Consultation Response from Emma Mills
KC Landscape

Application No:	2022/91477
Proposed Development:	Hybrid Planning Application for the erection of an industrial unit for E(g)/B2 /B8 use with associated access, parking, groundworks and landscaping in conjunction with an outline application for mixed use development use class E(a), E(b), E(g), B2 and B8
Location:	Land off Lindley Moor Road, Lindley, Huddersfield, HD3 3SX
Applicant/Agent:	D5 Planning
Planning Officer	RichardA Gilbert
Date Responded:	01.08.22
Responding Officer:	Landscape - HP
Responding Ref:	LL49

Setting – this layout for **Hybrid Planning Application for the erection of an industrial unit at land off Lindley Moor Road, Lindley, Huddersfield, HD3 3SX**

Project Name: Lindley Moor Road	Drawn: TH	Checked: MB	<b>FOR PLANNING</b>		
Drawing Name: Landscape Masterplan	Date: April 2022		E	MB	07.09.2023
Drawing No: DR-4823-01	Scale: 1:500 at A0		D	TH	27.09.2022
			C	TH	24.05.2022
			Rev	Drawn	Date

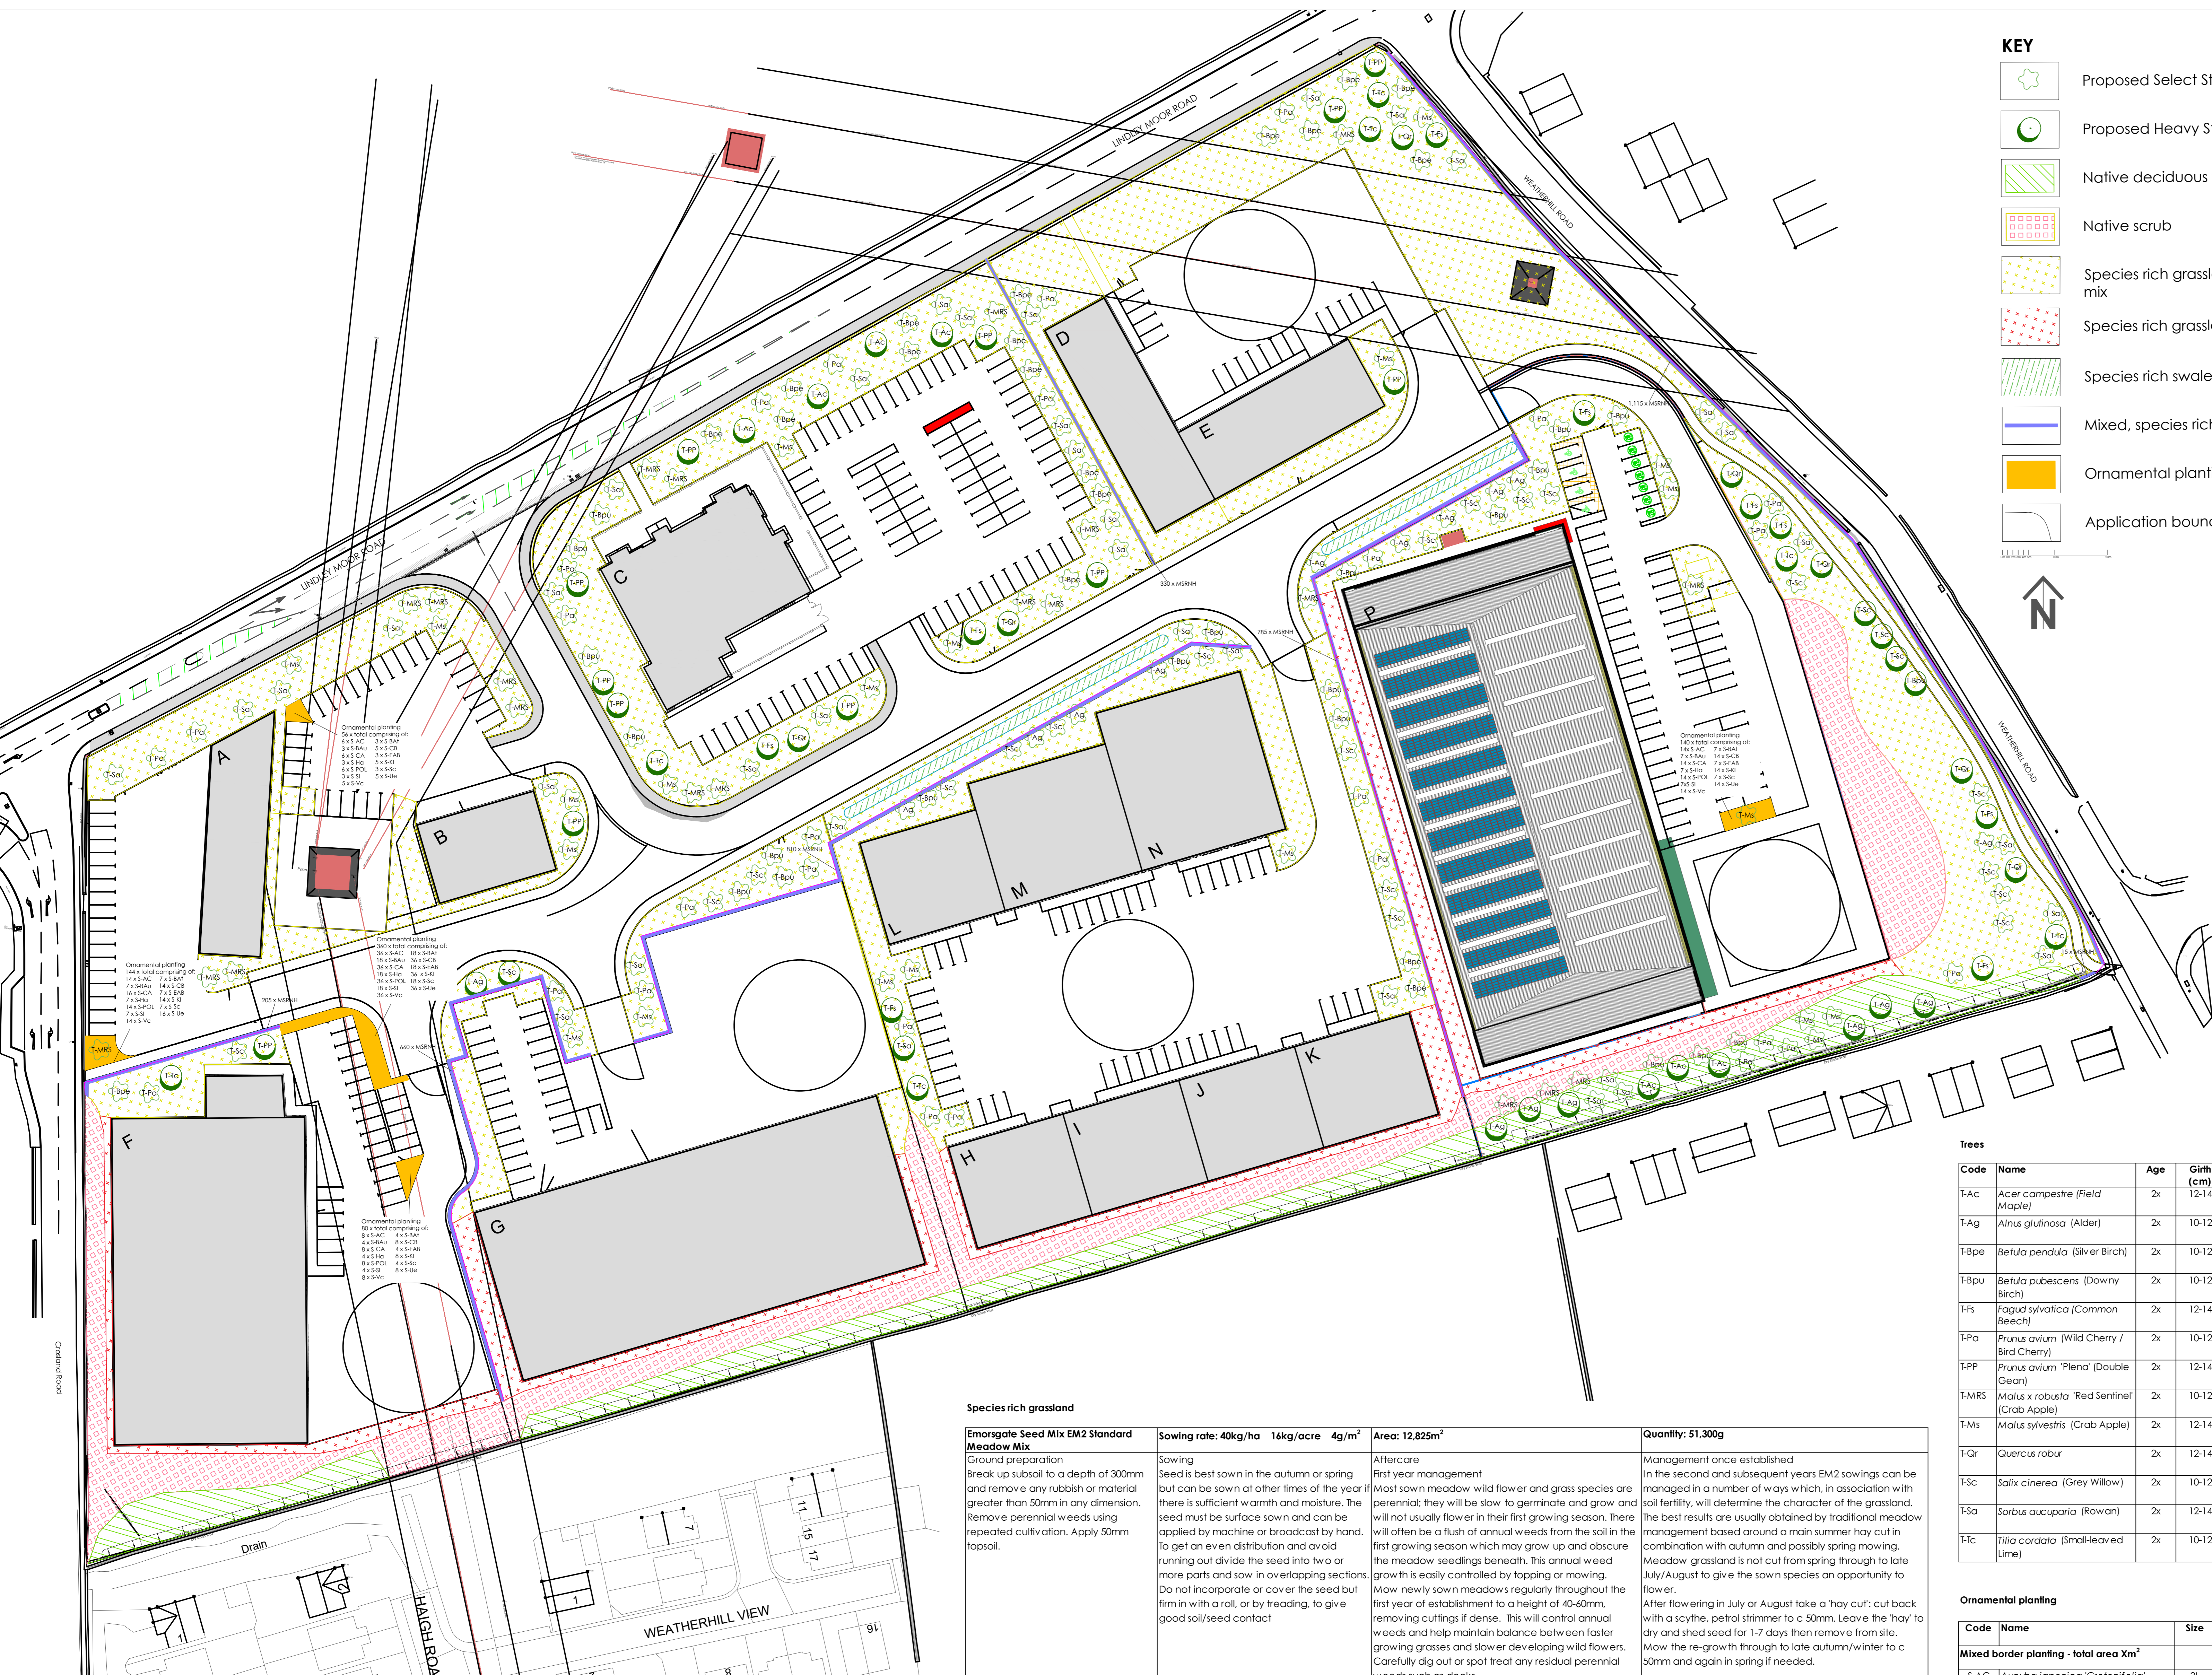
The proposed landscape layout drawing no. DR-4823-01 RevA is sympathetic to the existing landscape and setting, including areas of native species, light woodland mix and woodland edge mix planting and minimal ornamental planting within the site.

There is a good mix of native tree planting.

The tree planting needs to be reviewed on a plan showing the retaining walls. There are some trees shown almost on top of the walls, and many proposed far too close. Trees with strong growing roots as mentioned below (Betula, Prunus, Tilia) would prove particularly problematic, especially when planted on the upper level. This could be putting the stability of the walls in significant danger. Also the hedge NW of Building G appears to cross a retaining wall, which is an unusual approach.

T-Sc by Building L should be reconsidered – willows are more suited to more open, damp environments, and can cause damage to buildings over time. Ideally they should be 30m away from buildings.

Prunus and Betula species tend to have fast growing roots in the upper levels of the ground – this means they are prone to cause cracking and damage to hard surfaces. It would be advisable to keep these species at least 3m away from hard surfaces, preferably 5m away where feasible.

Tilia can cause damage to vehicles, buildings and hard surfaces by dropping sticky sap, and should be 20m from buildings to avoid the risk of roots damaging the building.

Confirmation of planting density required – both 1.5 and 2m centres are both specified.

How will weed growth be managed? There is no mention of weed control measures around the small trees. An allowance clearing excess growth from other plants should be considered.

The section of woodland to the south of the wetland area could be opened out, with a few trees in open grassland, to improve visibility on the adjacent PROW. (See comments below under PROWs.)

The indicative ornamental planting list includes Prunus laurocerasus ‘Otto Luyken’, a potentially invasive species, which should not be planted in this setting given the greenbelt locality and should be substituted with more appropriate less invasive species as they are on the Plantlife list of species to avoid. [Plantlife :: Here today, here tomorrow? / plantlife.org.uk/application/Here_today_here_tomorrow_2010_summary.pdf](http://plantlife.org.uk/application/Here_today_here_tomorrow_2010_summary.pdf)

The indicative ornamental planting list includes *Kalmia latifolia*. It is toxic to people and livestock, which is unlikely to be a significant issue on a scheme of this nature, but it is also an irritant to skin and eyes, which would affect maintenance personnel and anyone taking a shortcut through a shrub bed or walking between their car and the planting bed, etc.

Ensure that the *Berberis* species and *Ulex europaeus* are planted away from the edges of the bed to ensure they do not scratch people as they walk past.

There is some concern with how the areas could be cut – for example the upper level between buildings G and F there is no access for a mower, with the wall, hedge, and scrub appearing to block access. Mowing access on either side of the retaining wall to the East of Building A would also present challenges to maintenance teams.

The Transport Assessment states that cycle storage will be provided, however we cannot see this on the plan. Cycle storage should be throughout the site for users of different buildings, and should be in a secure, visible location to improve security. Please clarify locations and nature of proposed cycle storage.

Where the PROW HUD/410/10 passes on immediately adjacent to the site, tree planting should be away from the boundary and additional maintenance measures in place to ensure branches do not block the path as they grow into the light. This is a particularly thorny issue with species such as *Prunus spinosa*. A more open margin should be maintained at the Weather Hill Road end, where tall hedges at the back of Alderstone Rise and the proposed woodland would create a narrow, dark tunnel. This could create safety issues in terms of accessibility and visibility if not managed.

Most lighting appears to be designed with the tree locations taken into account, though this may need to be reviewed at the NW corner of Building P, where A2 is directly behind T-Bpu.

Where are the two acoustic fences due to be installed? These are mentioned but are not visible on the landscape plan. These could have significant impact on the visual amenity of the site.
